**KIRKLEES METROPOLITAN COUNCIL
INVESTMENT & REGENERATION SERVICE**

Reference No: 2020/62/91168/E

Site Address: 1, Patterdale Road, Dewsbury, WF12 7NP

Description: Erection of single storey side extension

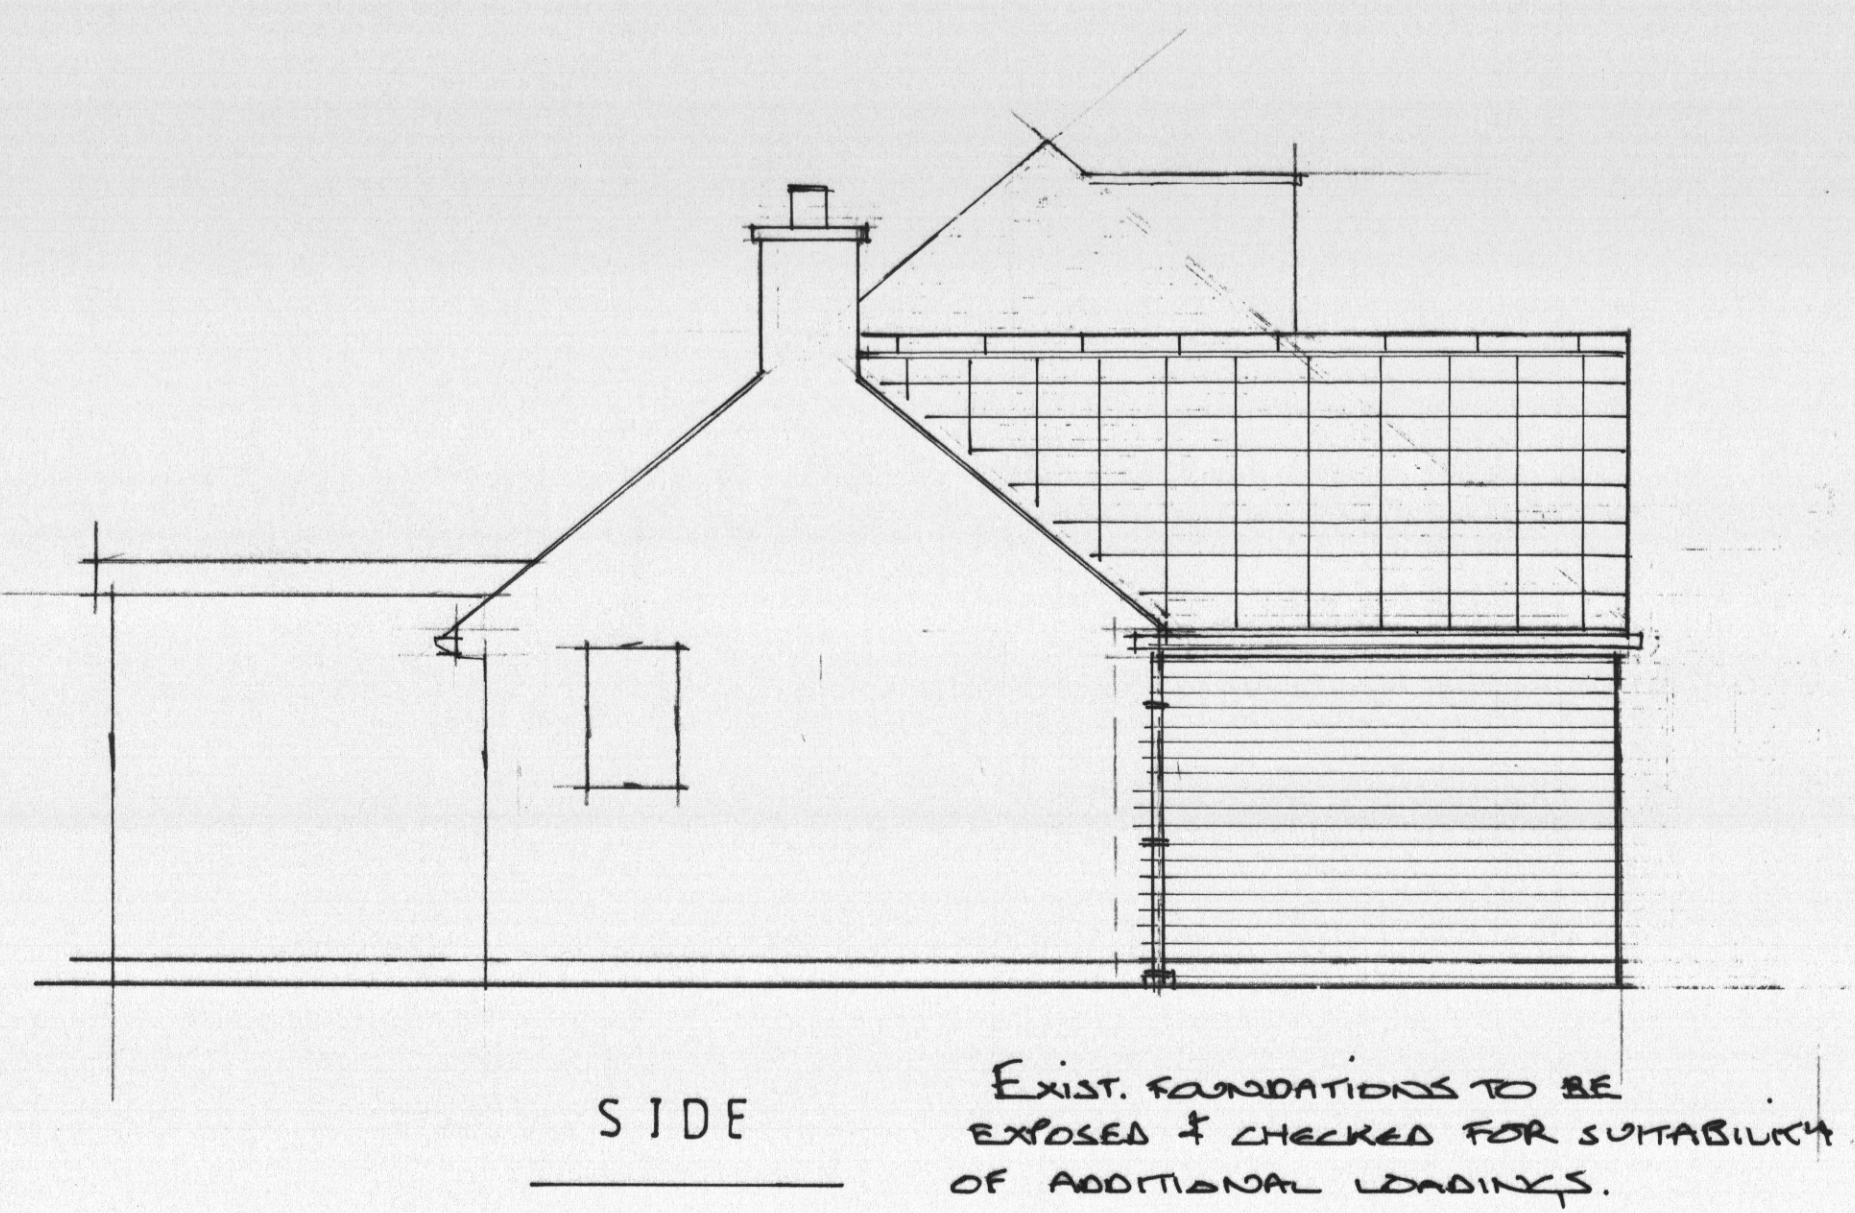
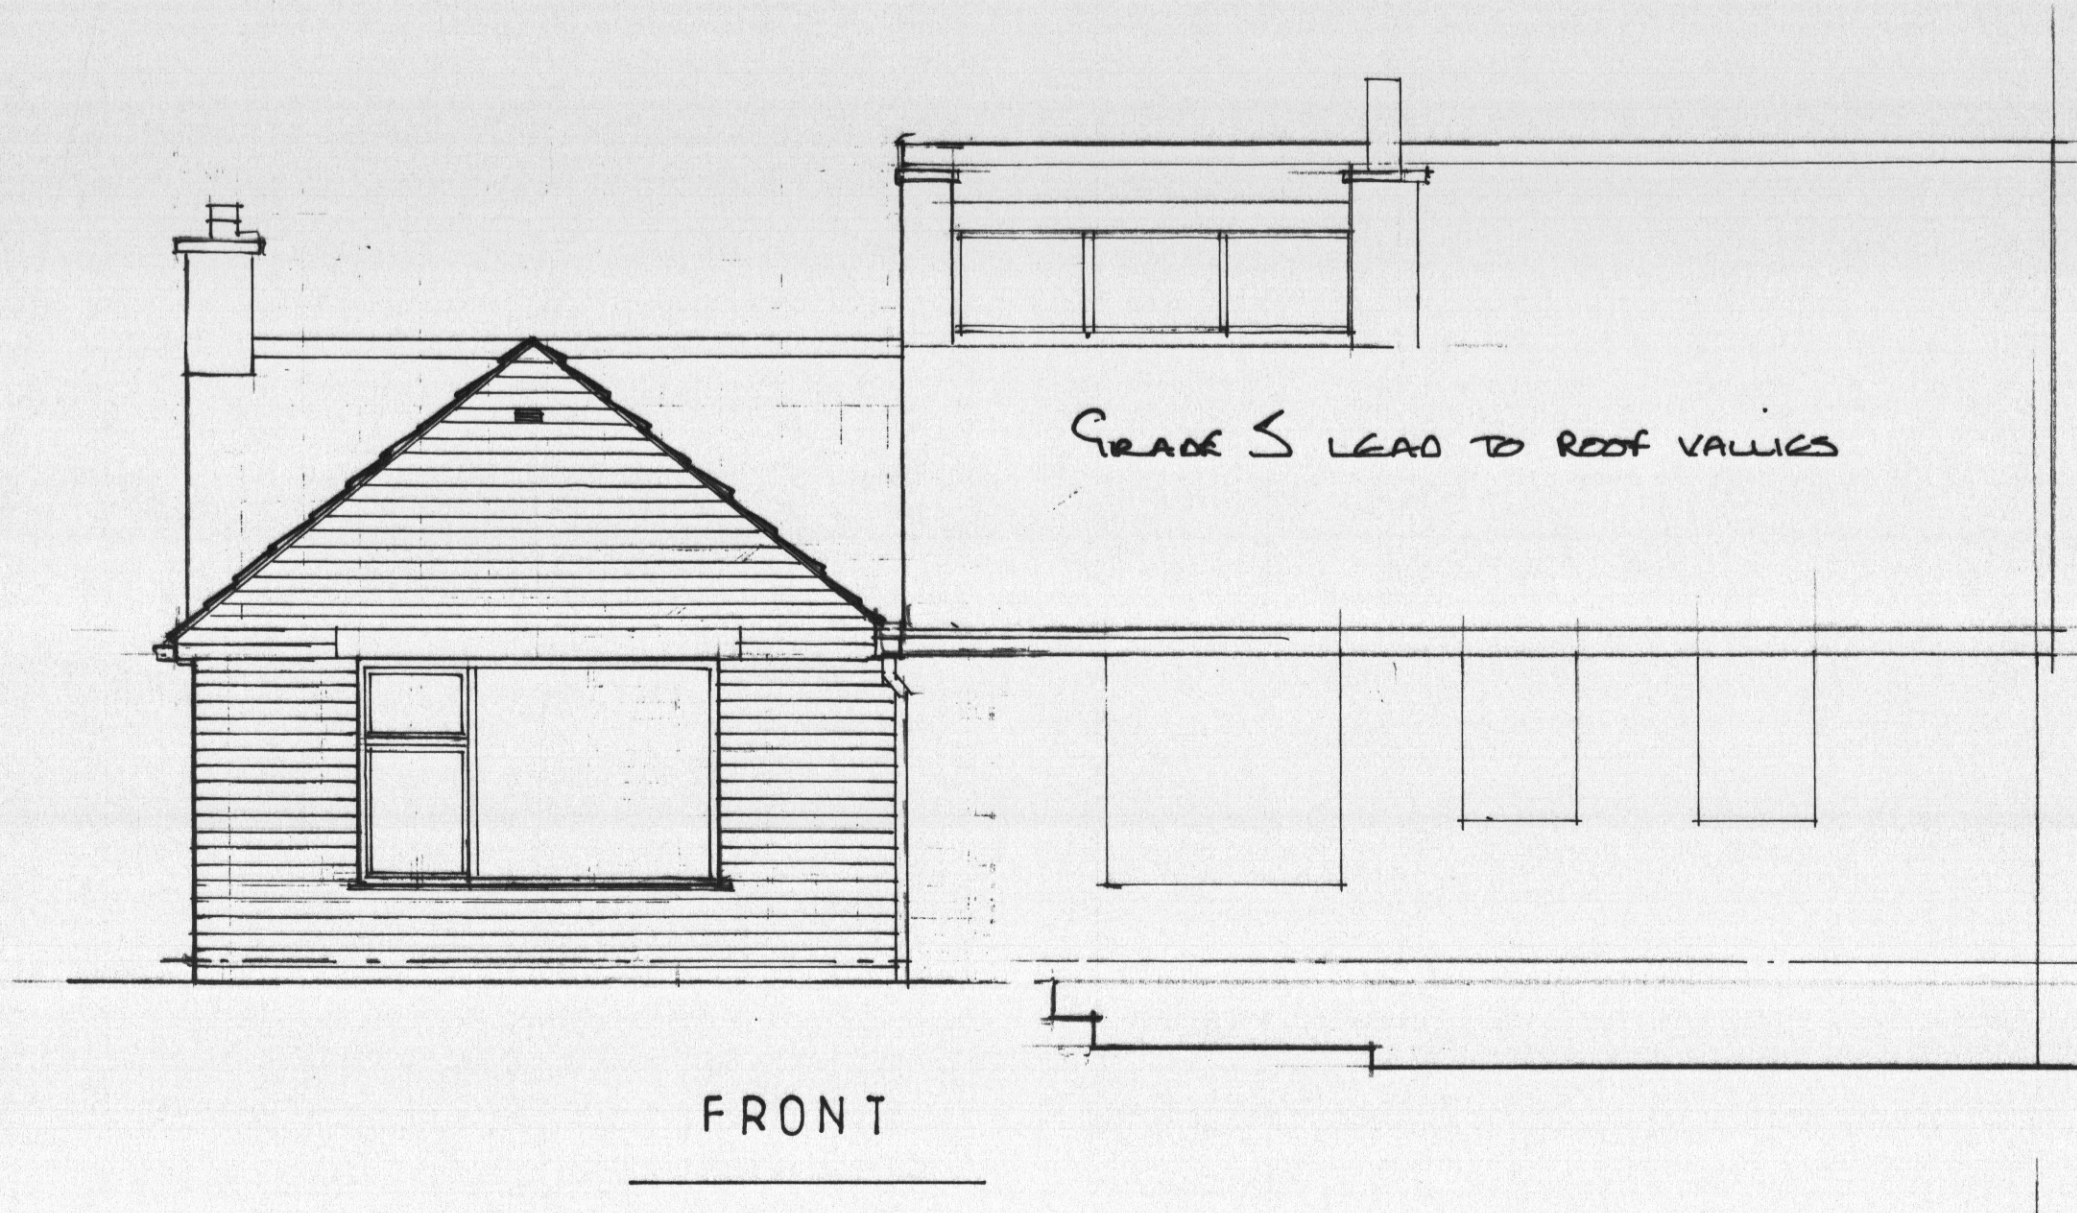
Amended plans were sought from the agent during consideration of the application to ensure that the submitted plans correspond with what has been built on site.

The amendments were limited to the correction of window openings. Whilst an opening has been introduced to the side elevation of the extension, given that the extension has been constructed and the opening is in place, it was considered that it would not be necessary for the amended plans to be advertised, in this instance.

overshadowing impact. There is a window in the side elevation of the extension, which serves a secondary opening to the living/dining room. Given the distance retained between the properties, as well as the fact that the application site is located at a slightly lower land level, it is considered that there would be no potential for harmful overlooking. This would be further limited by the existing boundary treatment, which comprises hedging.

Amended plans were sought, and received, during consideration of the application, to ensure that the submitted plans corresponded with what had been built on site.
